# MONA OFFSHORE WIND PROJECT

## Annex 7.3 to the Applicant's response at the Procedural Deadline

### Figure updates to address inconsistency between Onshore Works Plan and Environmental Statement figures (Volume 1, 2, 3, 4, 5 and 6)

Document Number: MOCNS-J3303-RPS-10235

Figure 1.2: SLVIA CEA study area (offshore)

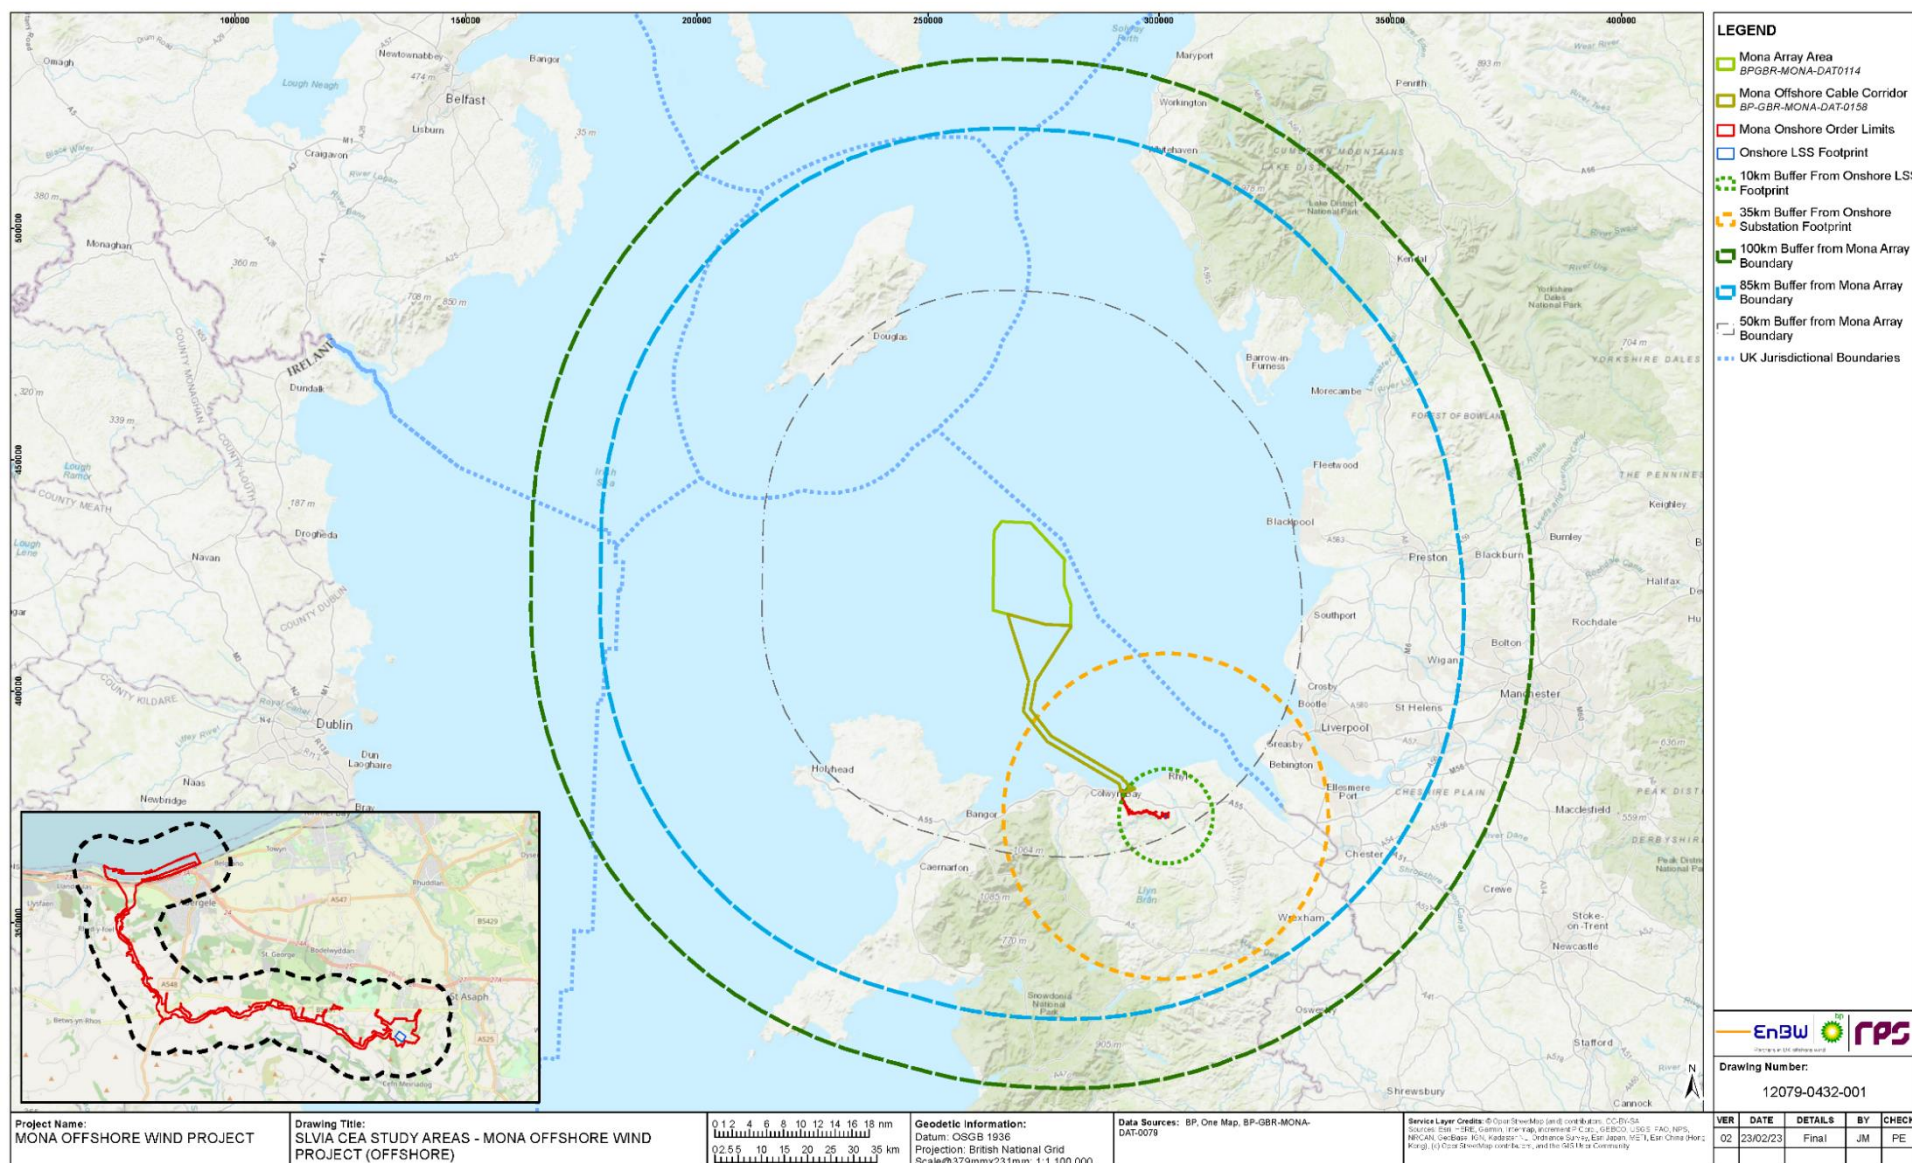
*Para 12.1 of the Application Letter (Doc A1) states that the proposed operational access to the existing National Grid Substation from the proposed Mona Substation access from Glascoed Road has been assessed in the Environmental Impact Assessment (EIA) but part of it is not currently shown on all the EIA figures.*

*The Inspectorate advises the Applicant to undertake a thorough audit of the ES figures to ensure that they are consistent with the Onshore Work Plan (Doc B3). Amended ES figures should be provided, together with a list of the figures subject to amendment.*

1.2.1.1 The Applicant has updated the figures of the Environmental Statement and other relevant application document figures as appropriate to show the proposed operational access to the existing National Grid Substation from the proposed Mona Substation access road. The figures that have been updated are provided below.

Figure 1.73: Figure 1.2 of Volume 6, Annex 8.4: Seascape, landscape and visual resources impact assessment methodology (APP-104).
